Application for removal or variation of a condition following grant of
planning permission. Town and Country Planning Act 1990.
Planning (Listed Buildings and Conservation Areas) Act 1990

Number	9
Suffix	
Property name	
Address line 1	Nursery Close
Address line 2	
Address line 3	
Town/city	East Preston
Postcode	BN16 1QD
Description of site location must be completed if postcode is not known:	
Easting (x)	507322
Northing (y)	102007

EP/145/17/HH

Condition number 5.
The dormer window on the north west elevation of the building shall at alltimes be glazed with obscured glass and only have a high level opening 1.7mabove floor level

DRAWN BY DJB	Scales (original on A1 to crop marks): Floor Plans 1 : 50 Sections 1 : 50
DATE September 2017	
DRAWING No. 17-085-2	REV -
 Protected By the Copyright, Designs & Patents ACT 1988

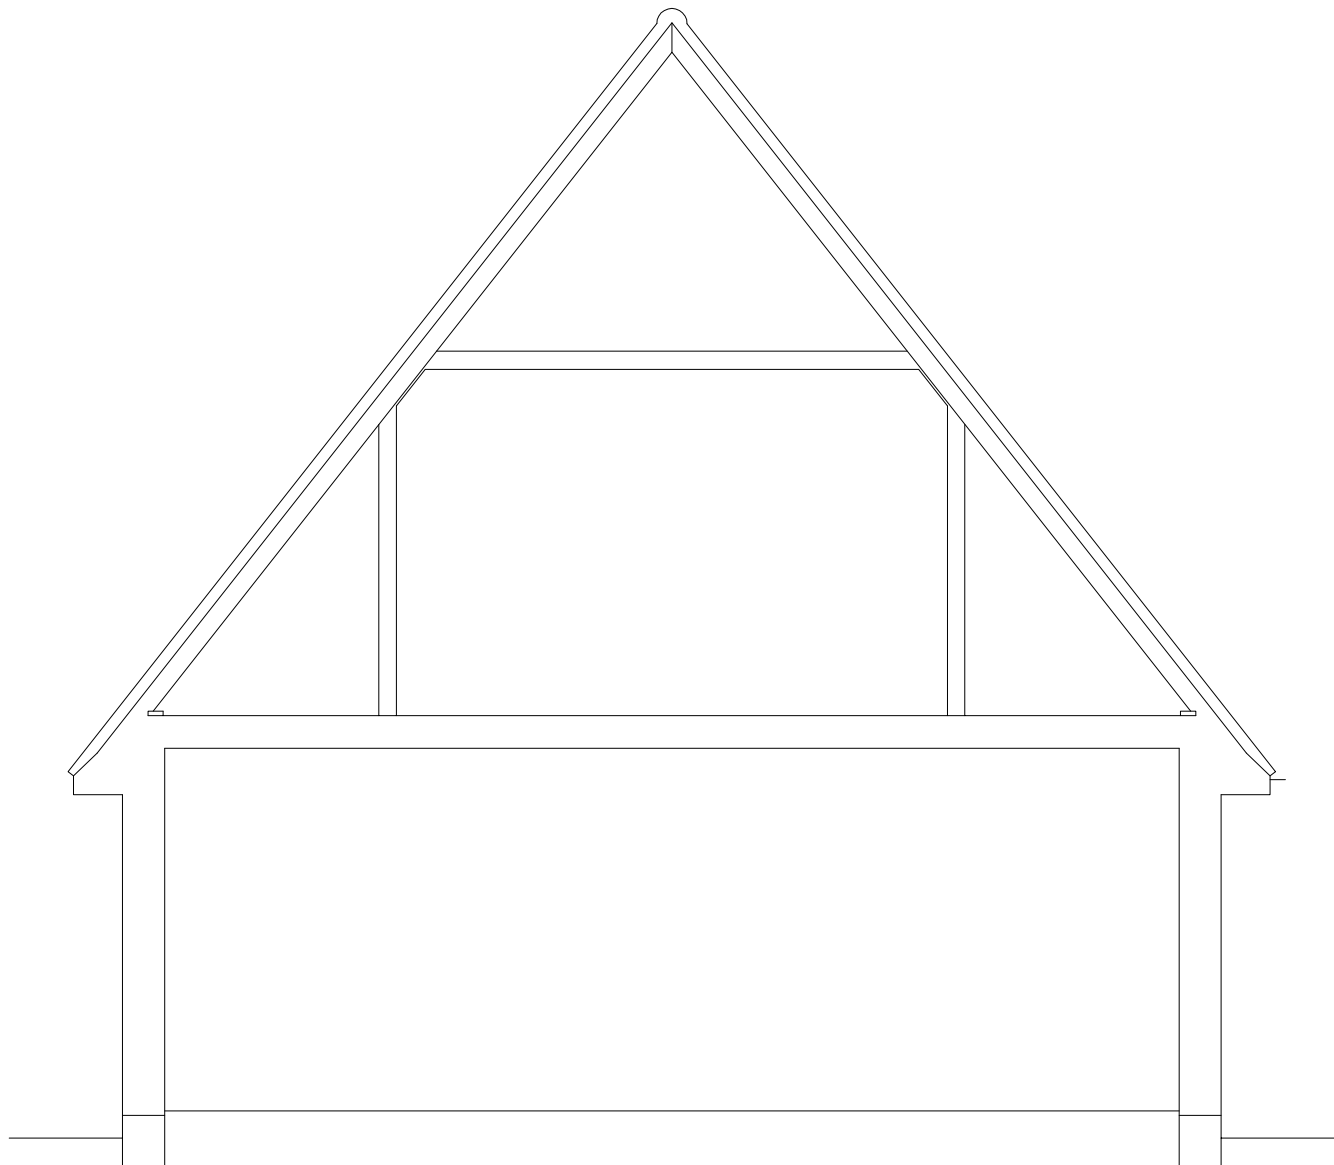
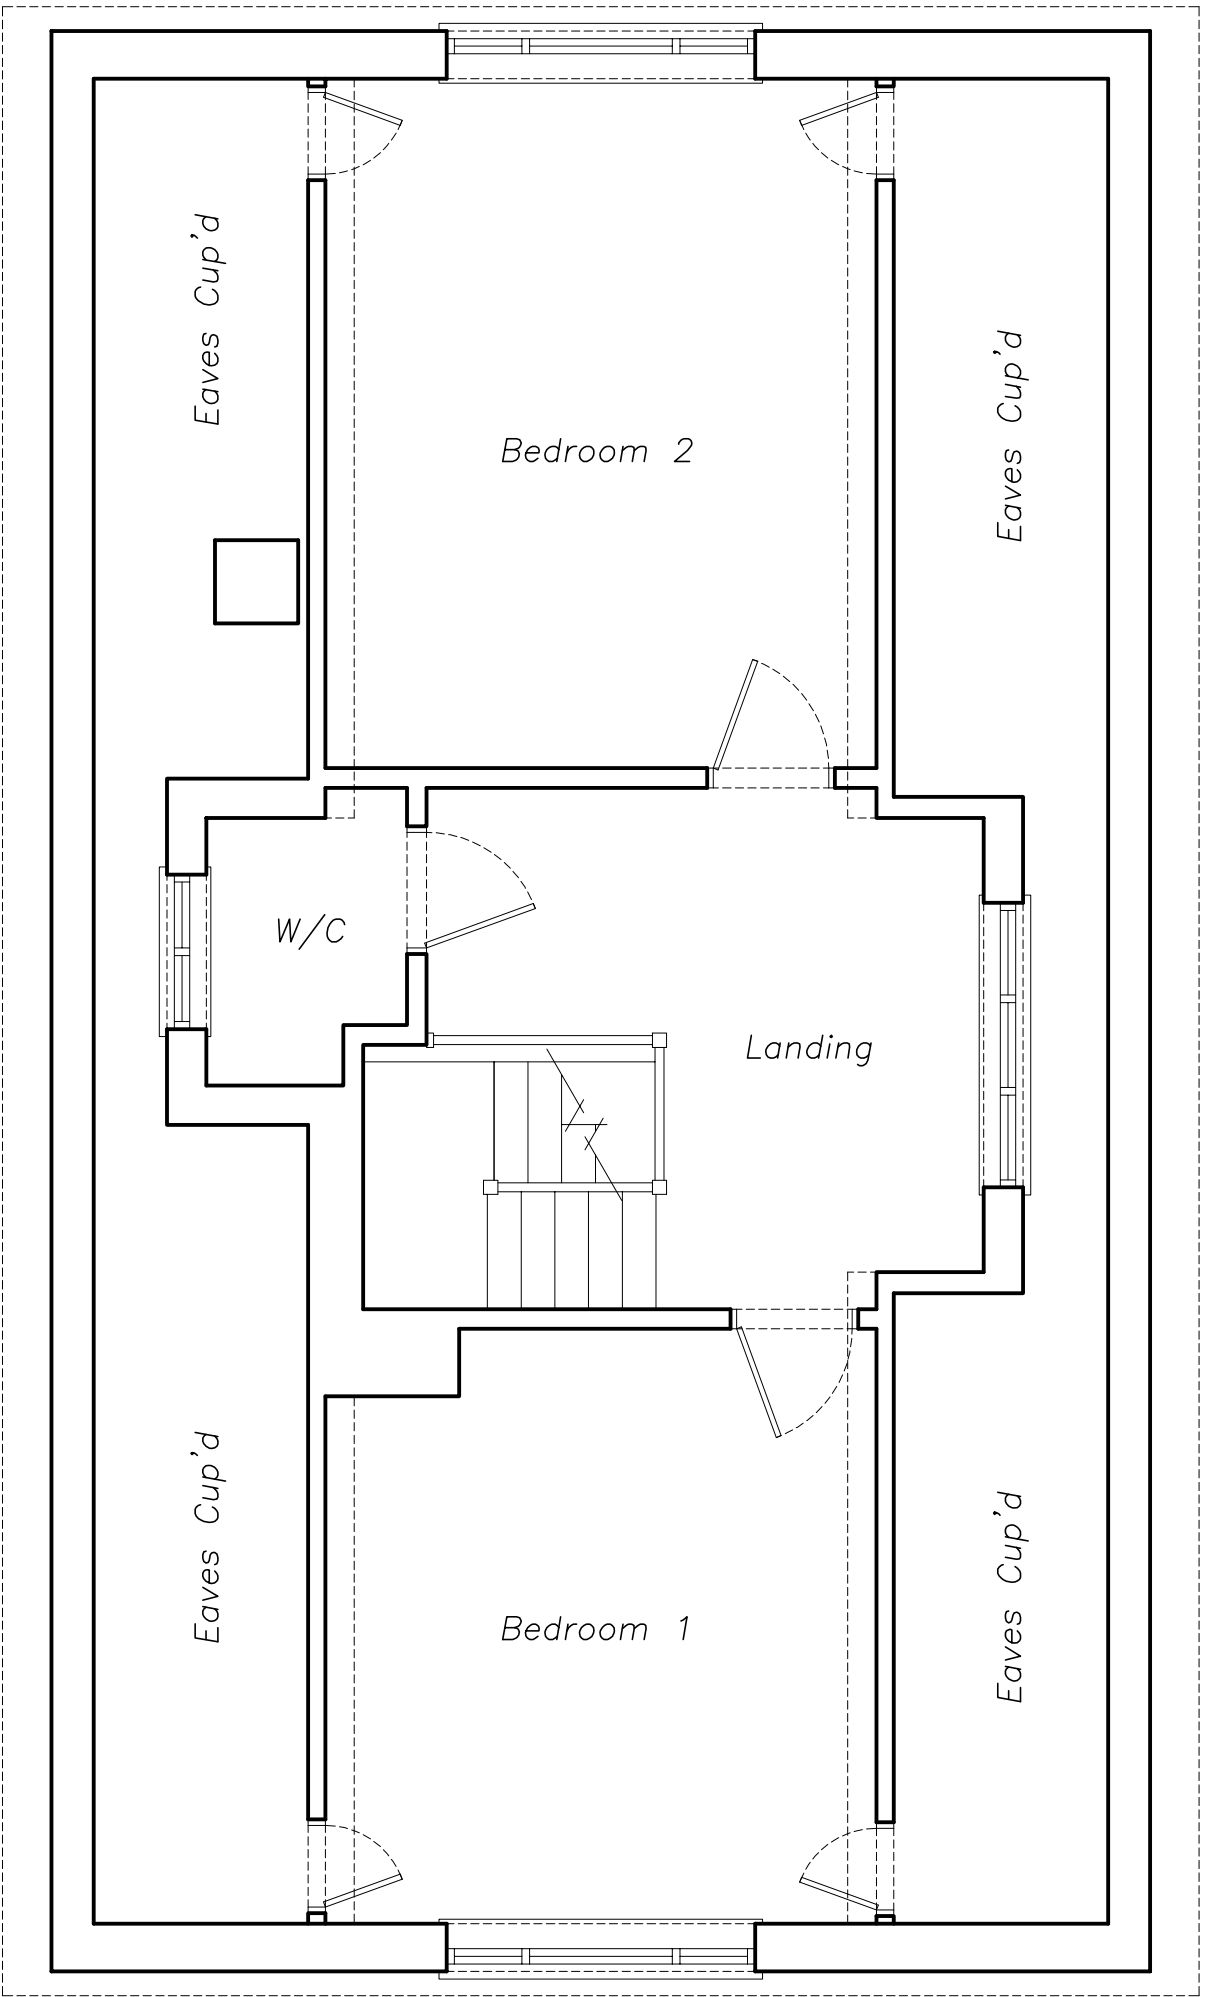
The planning officer's report recommends a "suitable planning condition" for the window to the North West dormer on his understanding that the proposal included "inserting a new dormer window extension". However, the dormer on the North West side existed since the house was built (see plans 17-085-2 and 17-085-3 and has always housed a WC. It can be seen from the plan 17-085-8 that the existing WC on the first floor was to be enlarged internally but the dormer would retain its original external footprint and was never to be enlarged.

Change requested: An obscure glazed, top hung window with restricted opening.

DRAWN BY DJB	Scales (original on A1 to crop marks): Elevations 1 : 50
DATE September 2017	
DRAWING No. 17-085-3	REV -

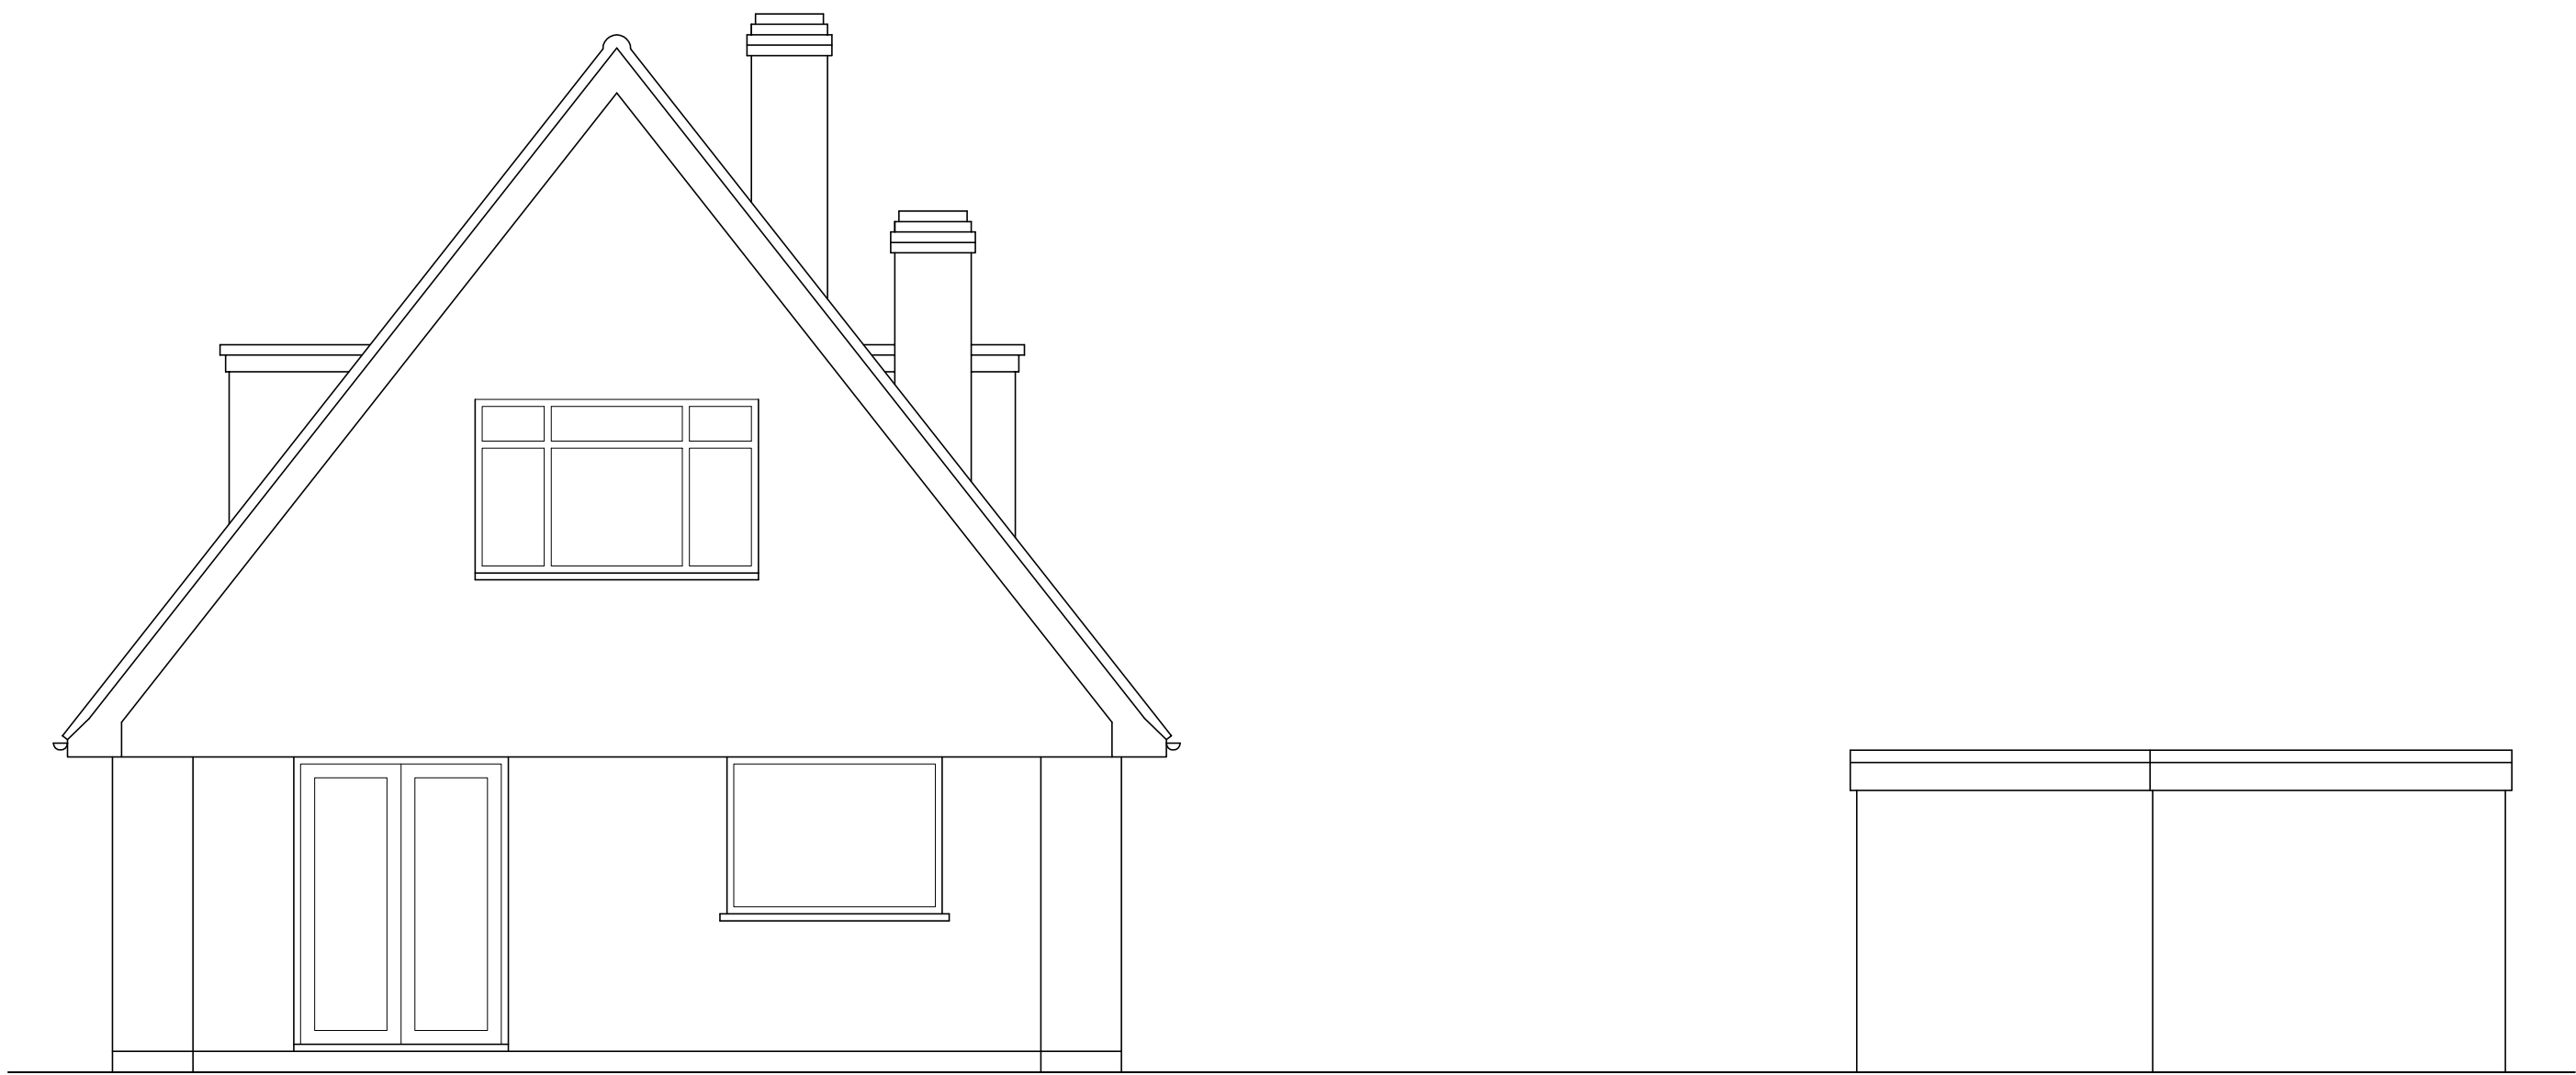
The changes proposed to the North West dormer were to replace the flat roof with a pitched roof and to replace the hanging tiles with cement-based cladding both in keeping with the rest of the refurbishment and modernisation of the property. The size and position of the window aperture has not changed. The original, 40 plus year old, window was separated by a central mullion, one half being side hung and fully opening and allowing an unimpeded view to the neighbouring properties; the other side fitted with a "fan light".

External view

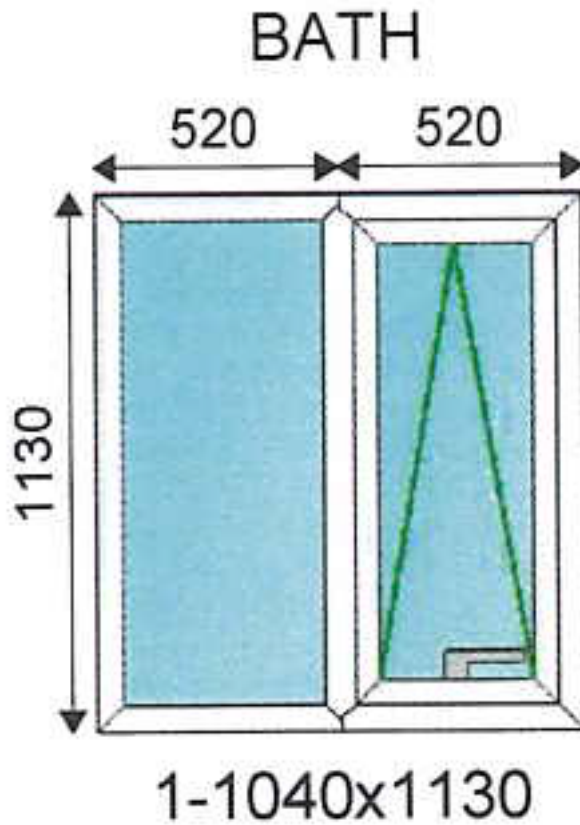
The proposed change would provide a window that is also separated by a central mullion, one half does not open at all and the other is top hung and is therefore more restricted in its opening than the original; in fact, it is also fitted with a restrictor which reduces the range of movement further. This arrangement does not actually represent any loss of privacy or outlook for the adjoining property when compared to the pre-existing window but, in fact, provides for a greater level of privacy for the adjoining property than existed for the previous 10 years or more since the extension to No 10 was completed.
